Arun District Council
Arun Civic Centre
Maltravers Road
Littlehampton
West Sussex BN17 5LF
Planning & Building Control General Enquiries
Tel: (01903) 737756 Fax: (01903) 730442
Dx: 57406 Littlehampton
Minicom: 01903 732765
e-mail: planning@arun.gov.uk
website: www.arun.gov.uk/planning

Application No: FG/57/22/PL
Site Address: 12 Little Paddocks Ferring BN12 5NJ
Description of works: Demolition and erection of 1 No new dwelling. This application is in CIL Zone 4 and is CIL Liable as new dwelling.

Thank you for your internet representation made on 12th May 2022 which has been recorded as an objection with the comments as follows:

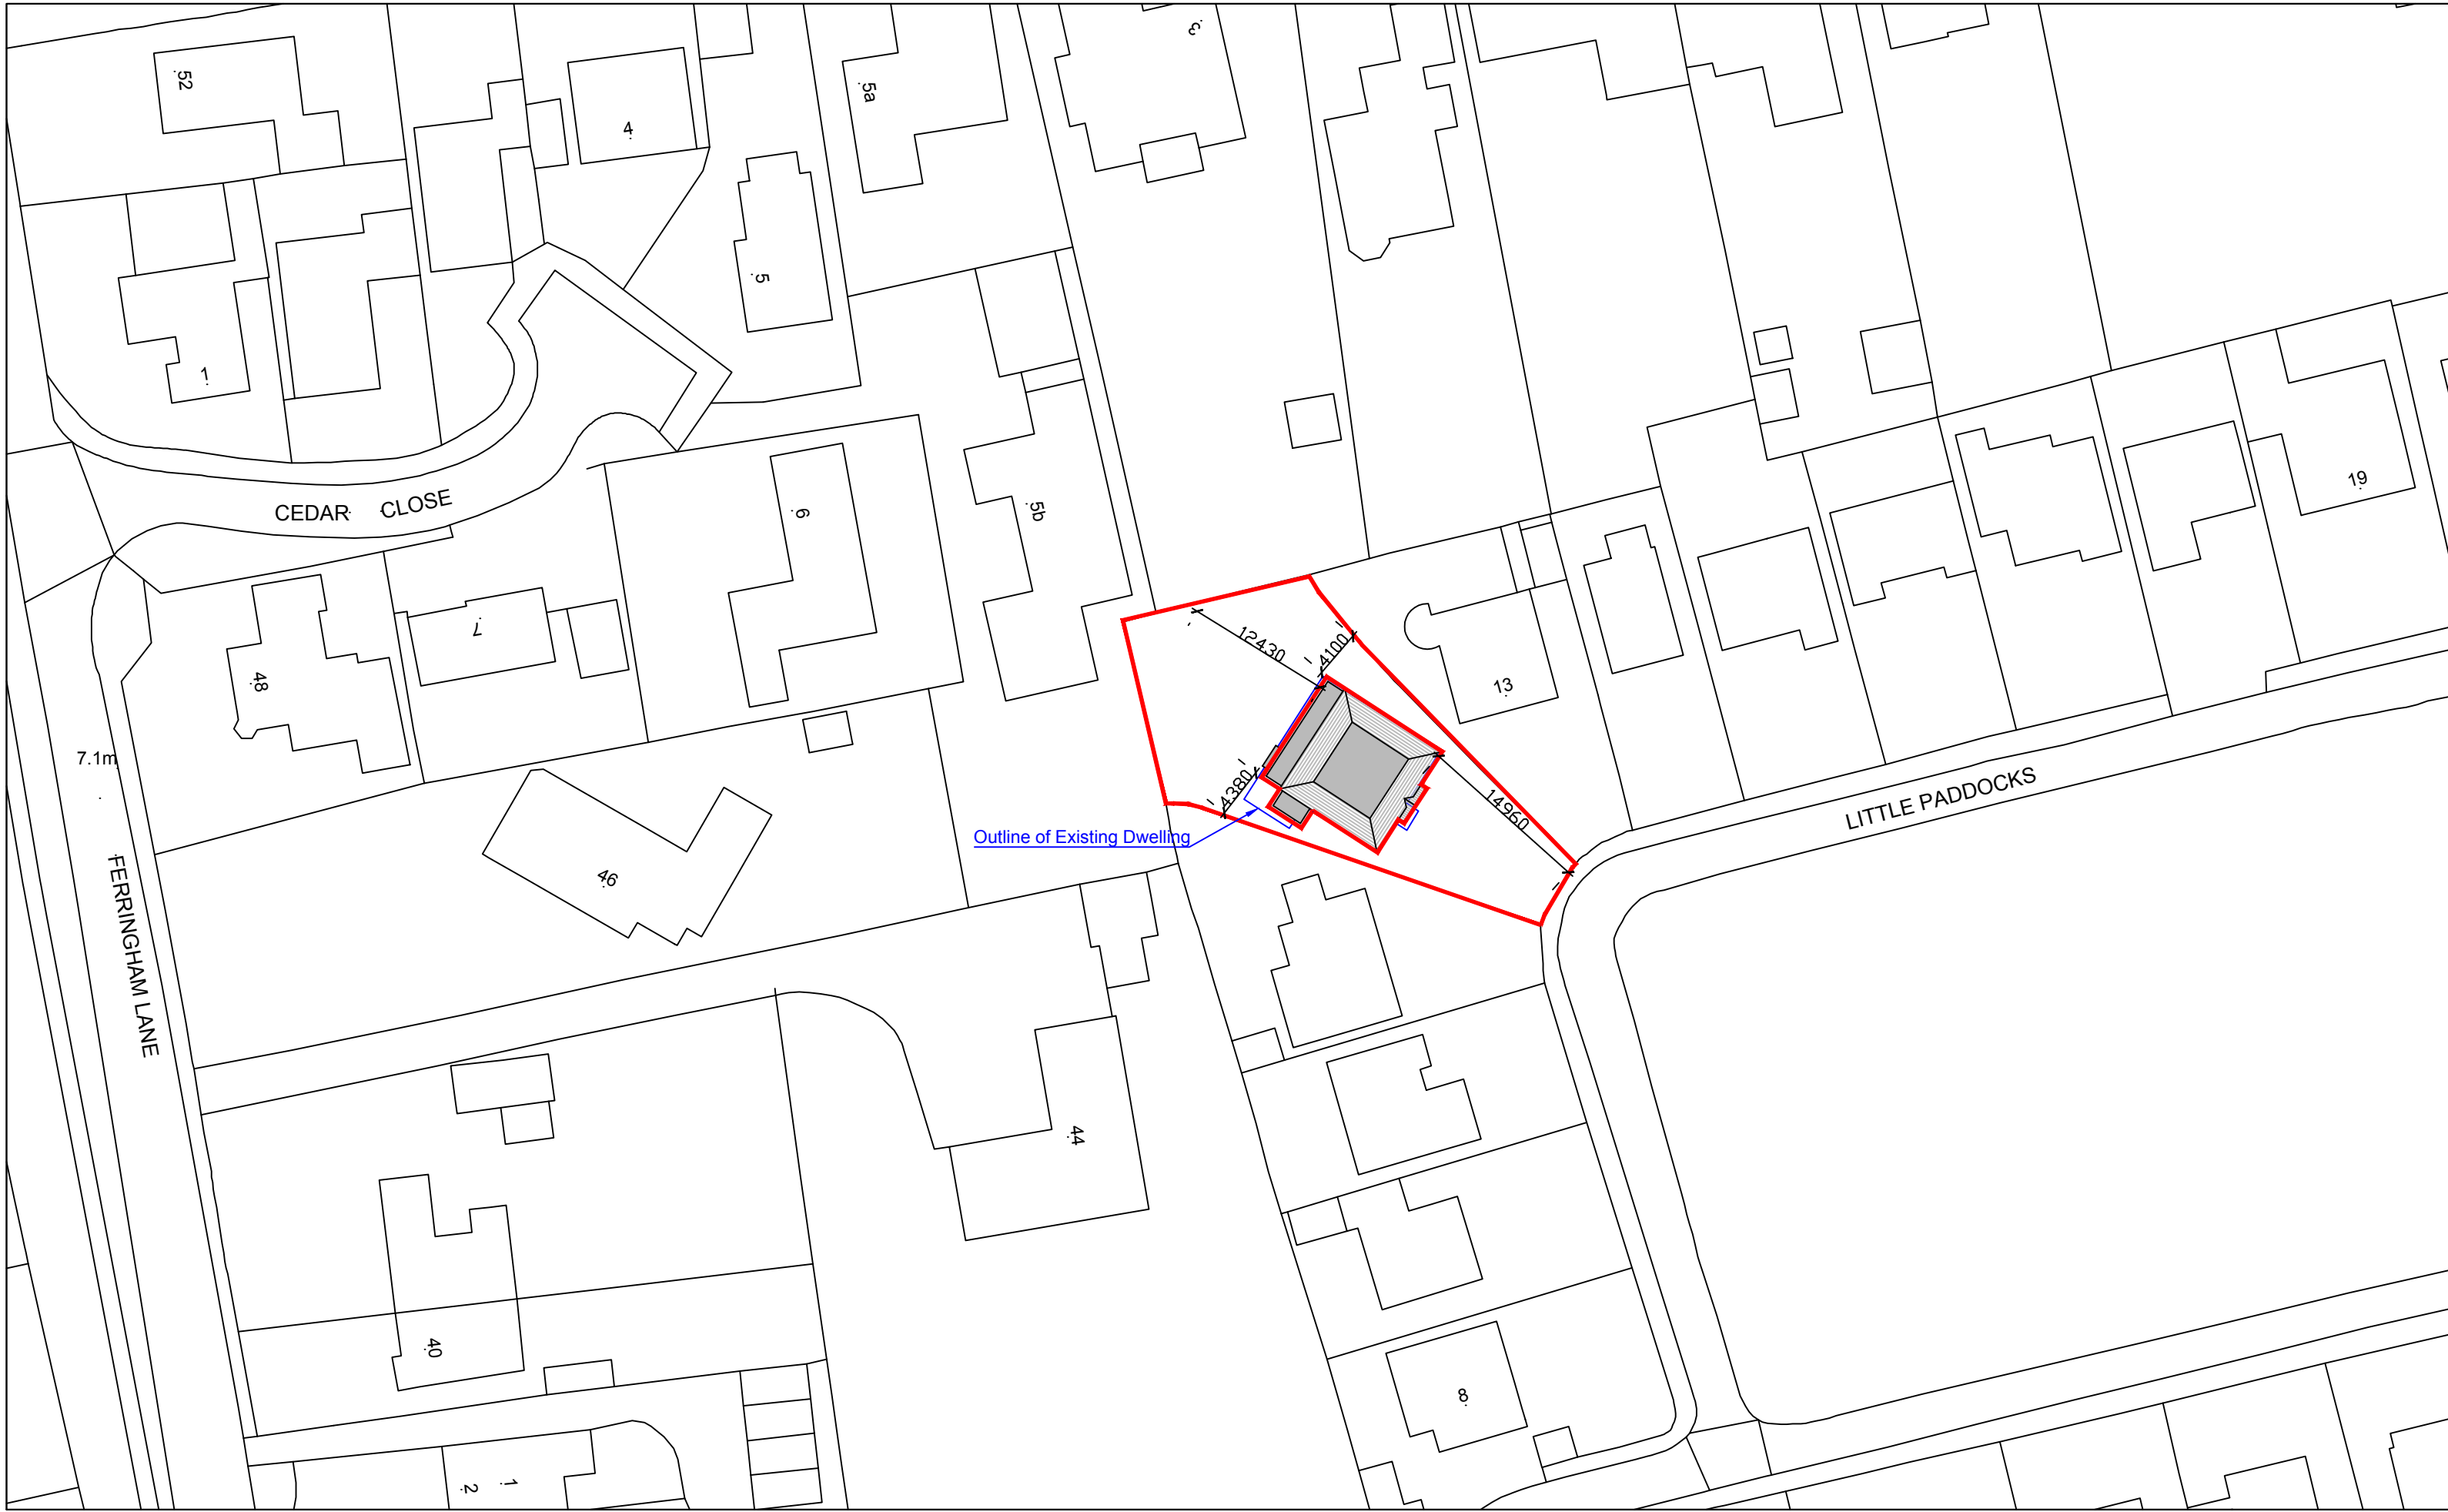
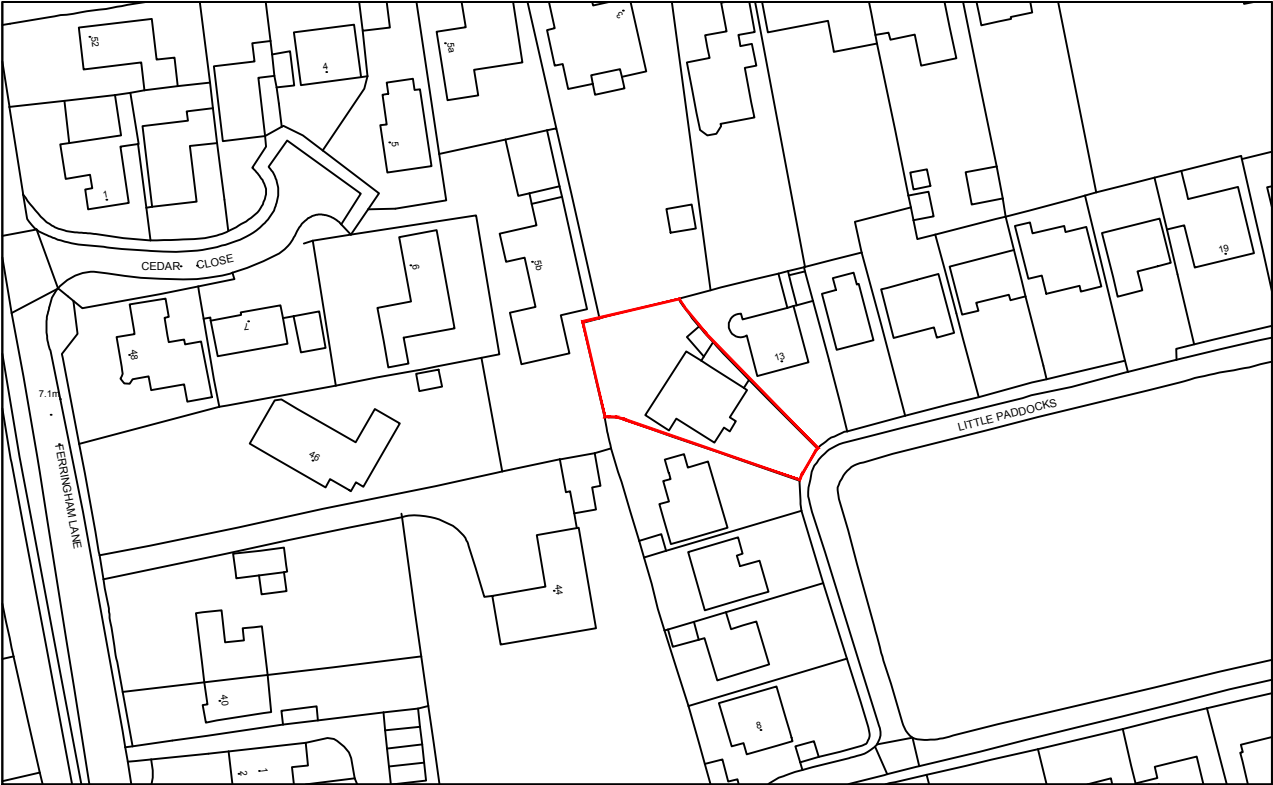
The boundary line on the plans between no 12 & 13 appear to be incorrect and I suggest that this is clarified before any further applications are made.
